Subject: Meridian Service Metro District Well Site 5, 7, & 8 (PPR2131)

The Community Services Department has reviewed Meridian Service Metro District Well Sites 5, 7, & 8 and has the following administrative comments of behalf of El Paso County Parks. This application does not require consideration by the El Paso County Park Advisory Board.

ARCHITECTURAL FLOOR PLAN
(WELL HOUSE 7 & 8)
SCALE: 3/8"=1'-0"

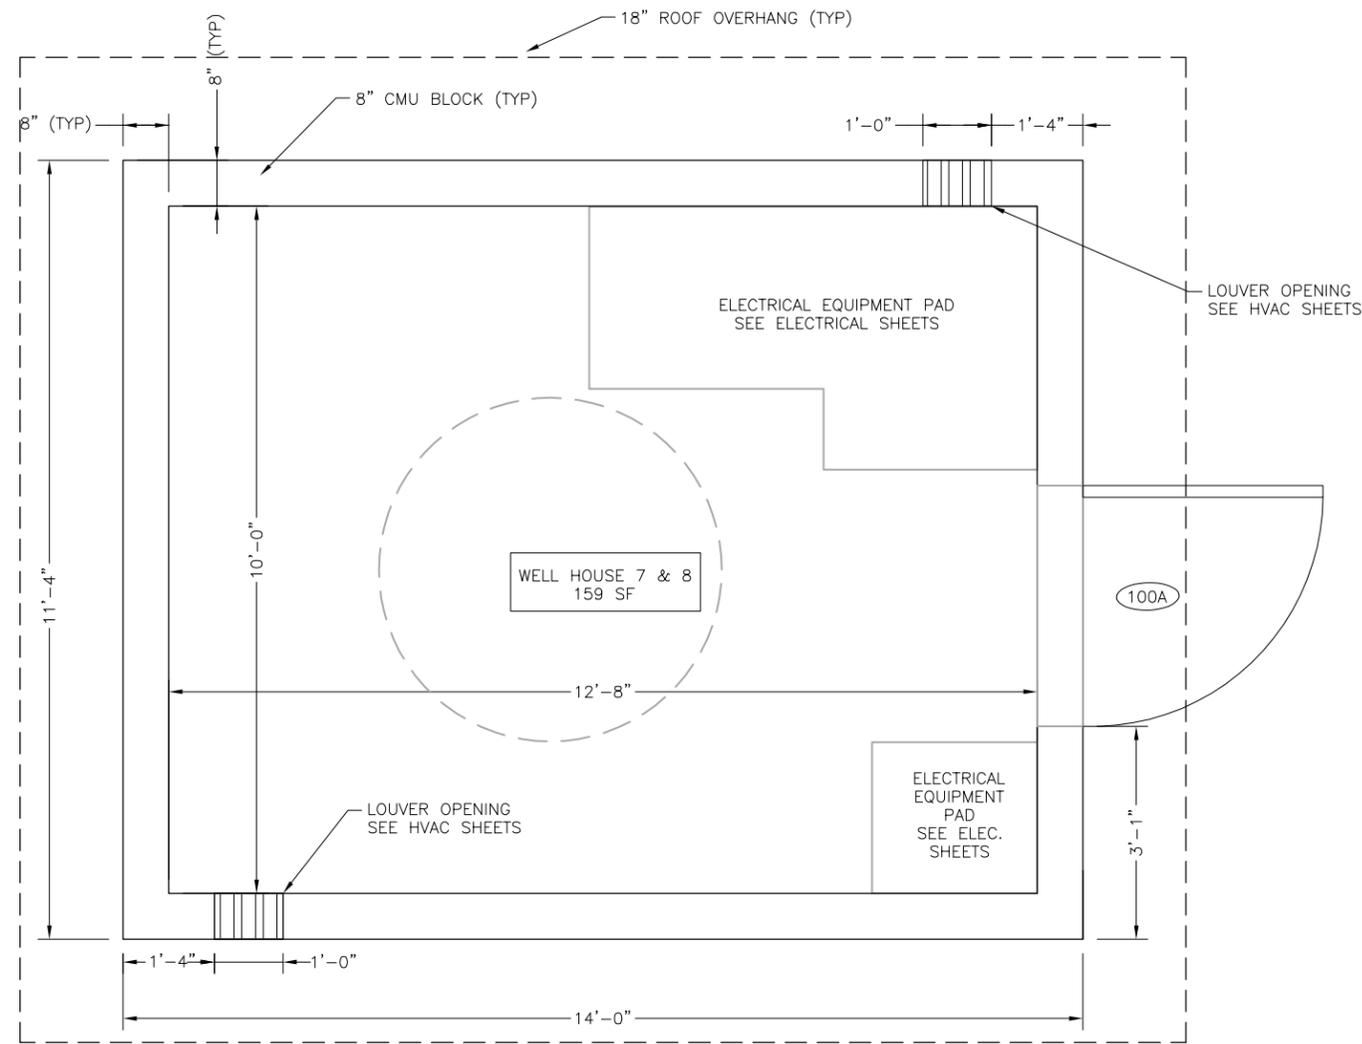
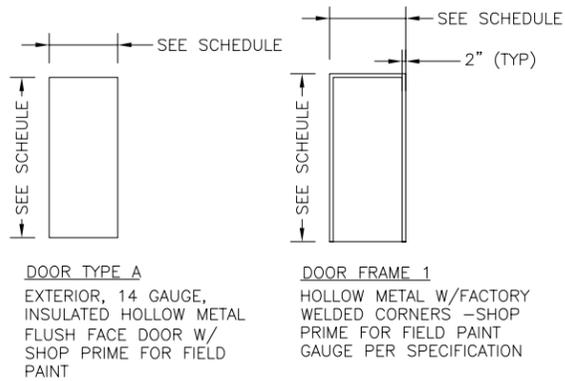
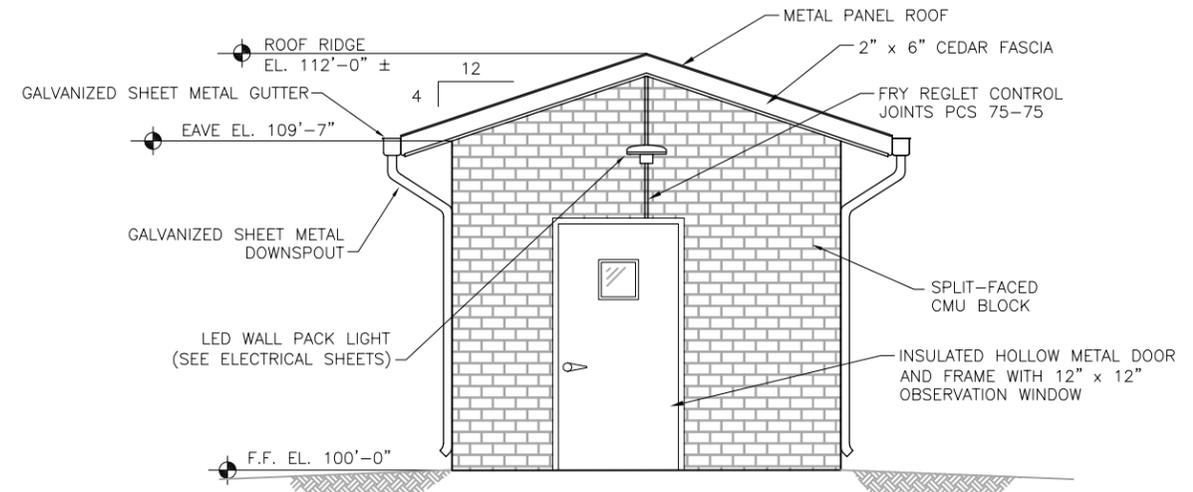
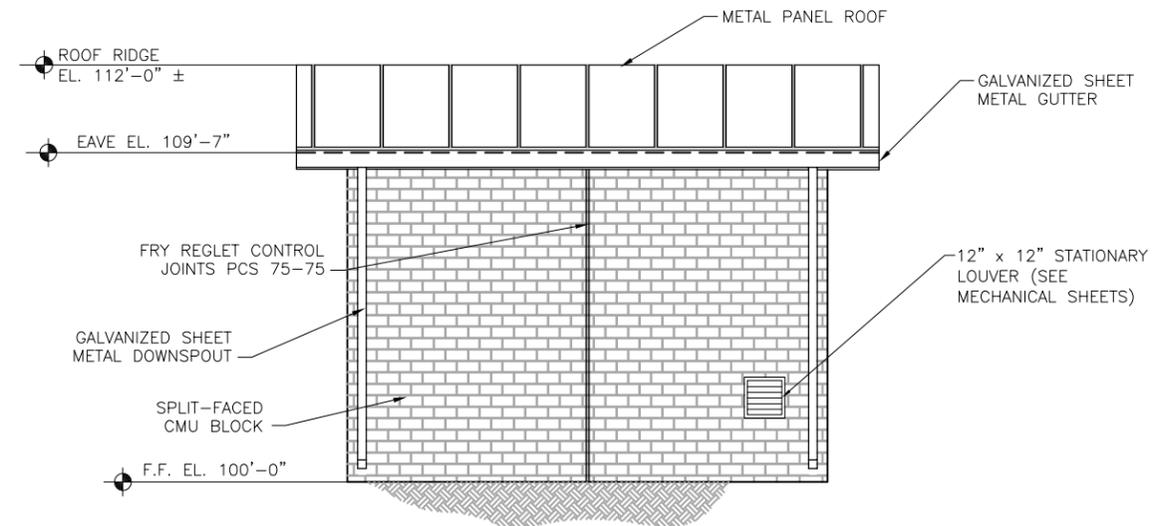
For the building design and lighting plan for well site #7 and well site #8, Staff appreciates the Districts willingness to match the aesthetics of the regional park. When appropriate, Staff would ask that the District coordinate with County Parks regarding color selection of the security fence, building color, and roof color for well site #7 and well site #8.
